# Comments for Planning Application 21/00120/FUL

Application Number: 21/00120/FUL

Address: 8 Staunton Road Oxford Oxfordshire OX3 7TW

Proposal: Demolition of existing garage. Erection of a part single, part two storey side and rear extension. Insertion of 1no. dormer to rear roofslope, insertion of 2no. rooflights to south roofslope and 1no. rooflight to front roofslope in association with loft conversion.

SITE PLAN DETAIL - 1:200

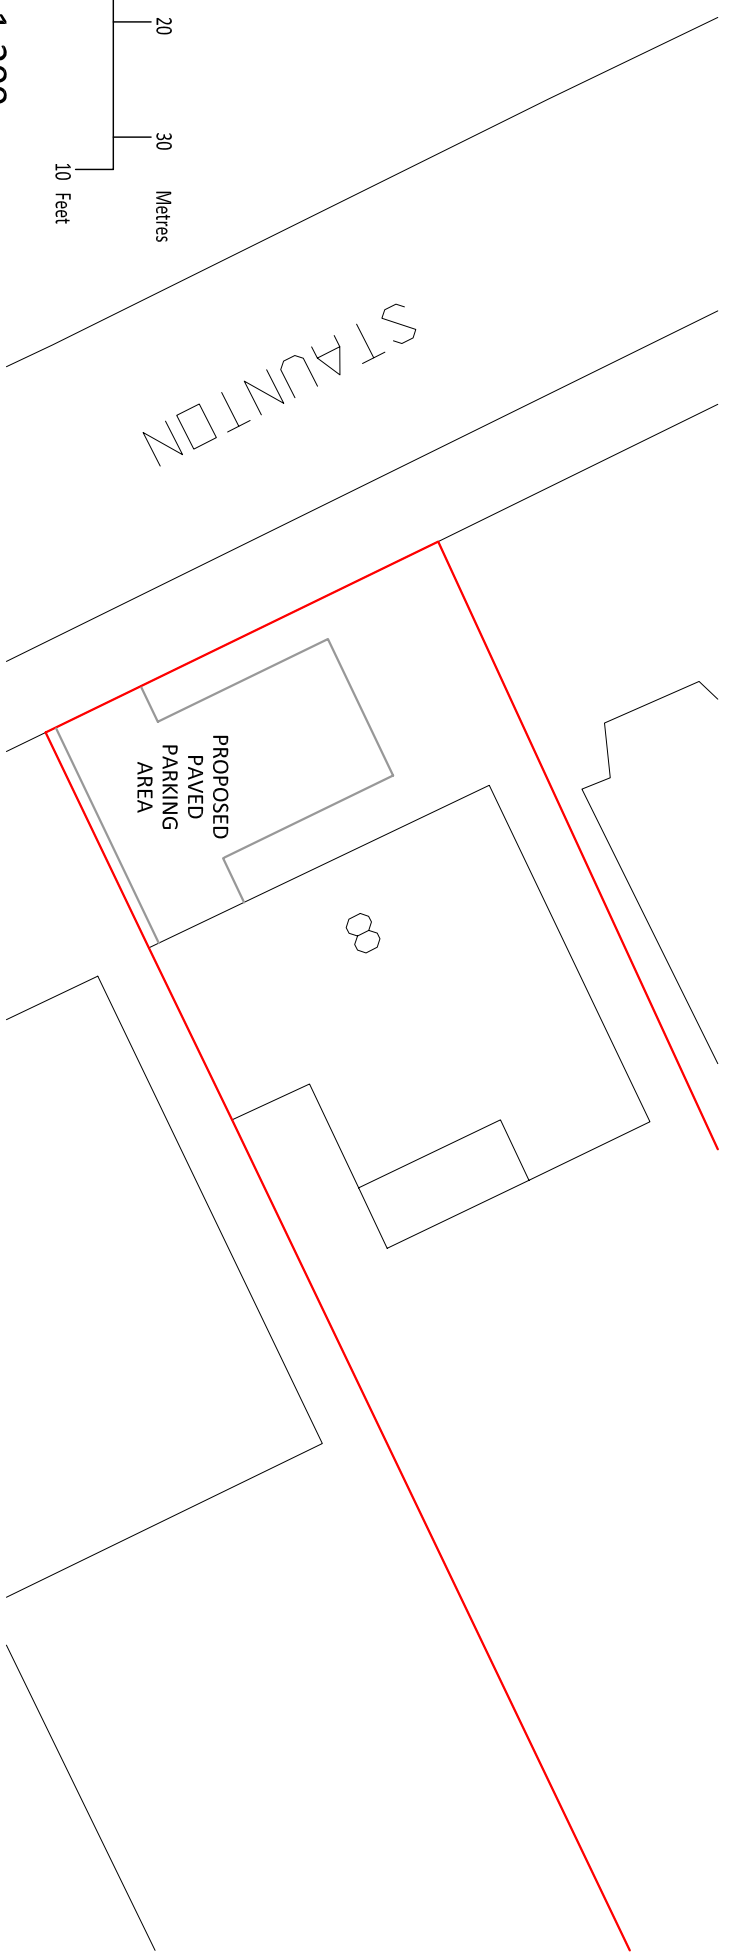
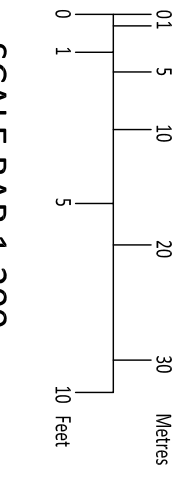
Cycle Parking - The property must demonstrate 3+ covered and secure parking space to conform with 2036 local plan policy and be considered acceptable.

Car Parking - The net impact of the proposals is 2 additional bedrooms. This has potential to increase parking demand at the site. The dwelling should be excluded from obtaining residents parking permits. This will protect existing on-street parking from the impact of the development.

Before the development permitted is commenced details of the cycle parking areas, including dimensions and means of enclosure, shall be submitted to, and approved in writing by, the Local Planning Authority. The development shall not be brought into use until the cycle parking areas and means of enclosure have been provided within the site in accordance with the approved details and thereafter the areas shall be retained solely for the purpose of the parking of cycles.

The development/proposed unit(s) shall be excluded from eligibility for parking permits prior to occupation. A cost of £2200 to amend the Traffic Regulation Order shall be met by the applicant through a Unilateral Undertaking.
